Re: Circle K – Eagle Ranch & Irving at 9620 Eagle Ranch Blvd NW
Erosion and Sediment Control Plan
Engineer’s Stamp Date – 9/13/2023 (C13E028)

Based upon the information provided in your submittal received 12/11/2023, the above referenced ESC Plan cannot be approved until the following comments have been addressed.

**EROSION CONTROL PLAN - INITIAL**

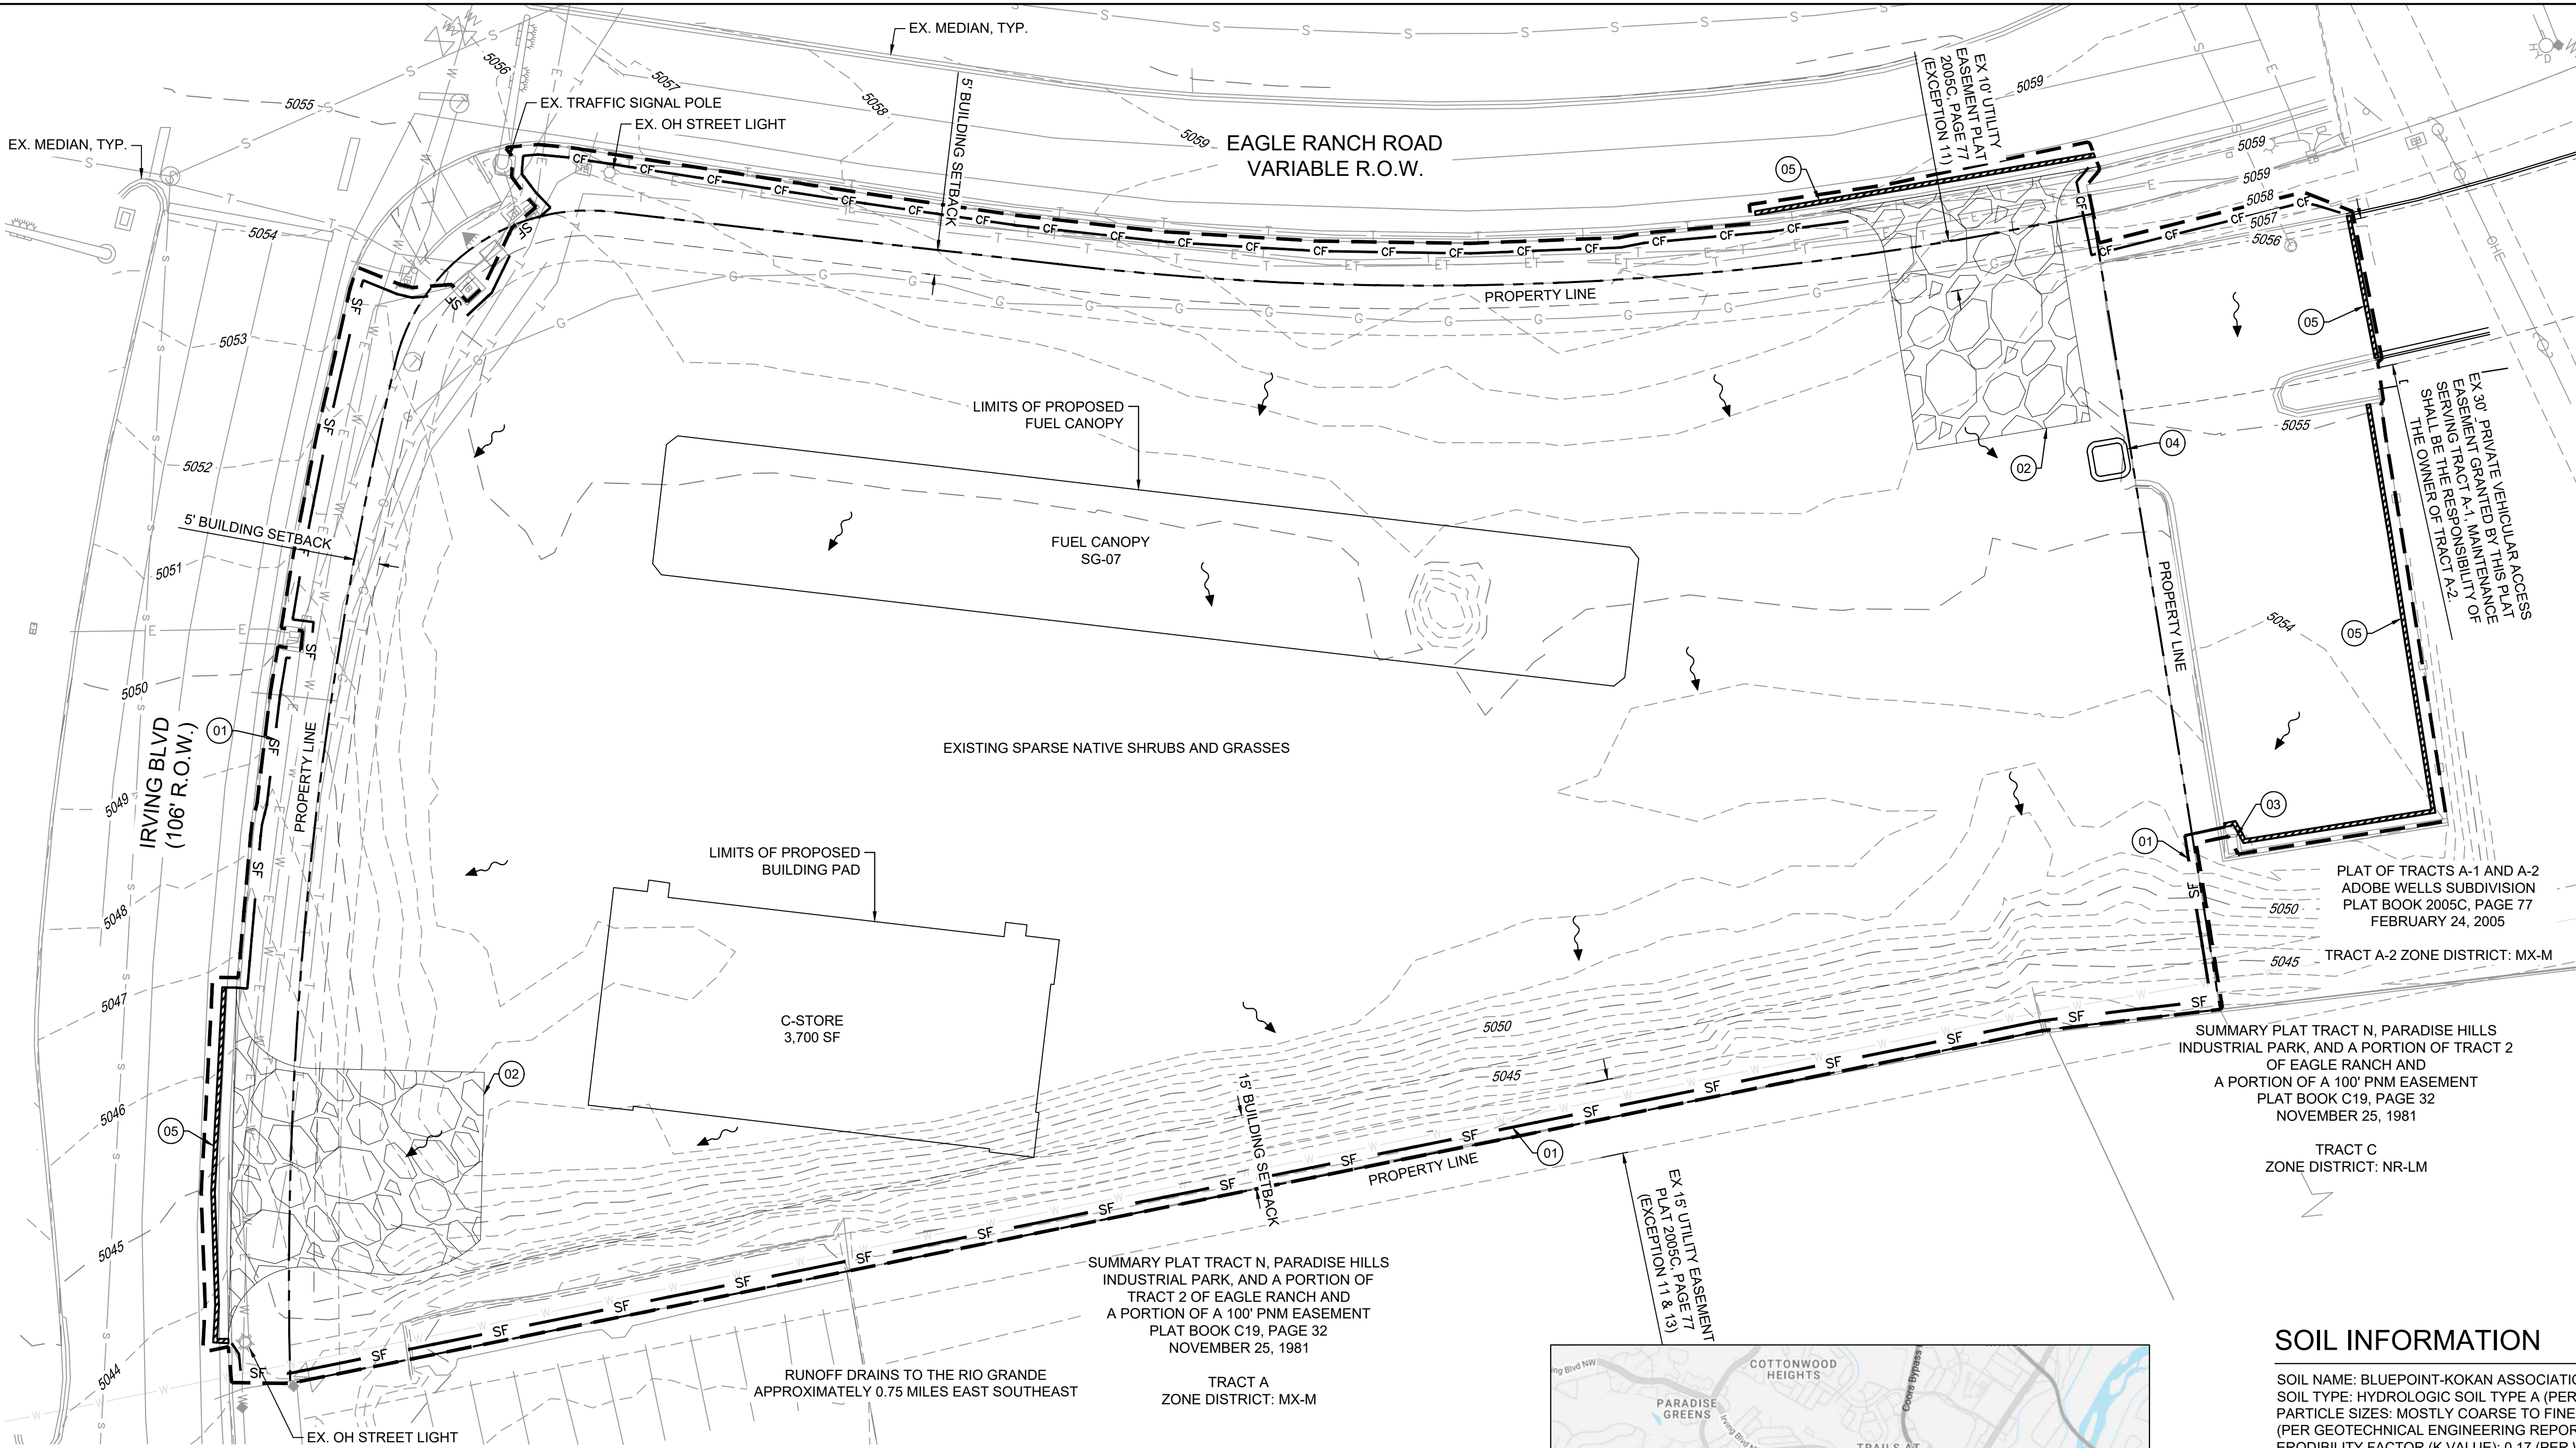
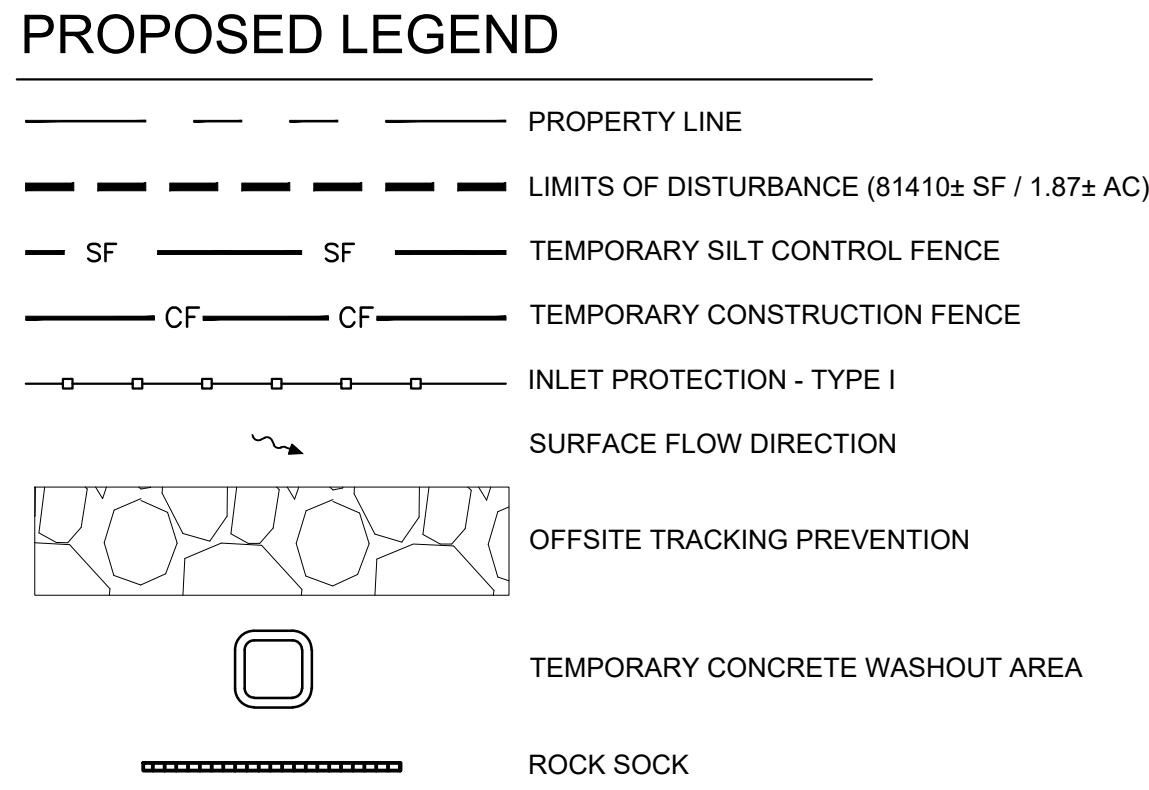
- 1. Perimeter controls (Silt Fence) is required per CGP 2.2.3 and must be shown on the ESC Plan. On its own, Construction Fencing along Eagle Ranch Road is not a sufficient stormwater control measure; it will need the addition of a proper stormwater control. Construction fencing has been replaced with silt fence along Eagle Ranch Road.
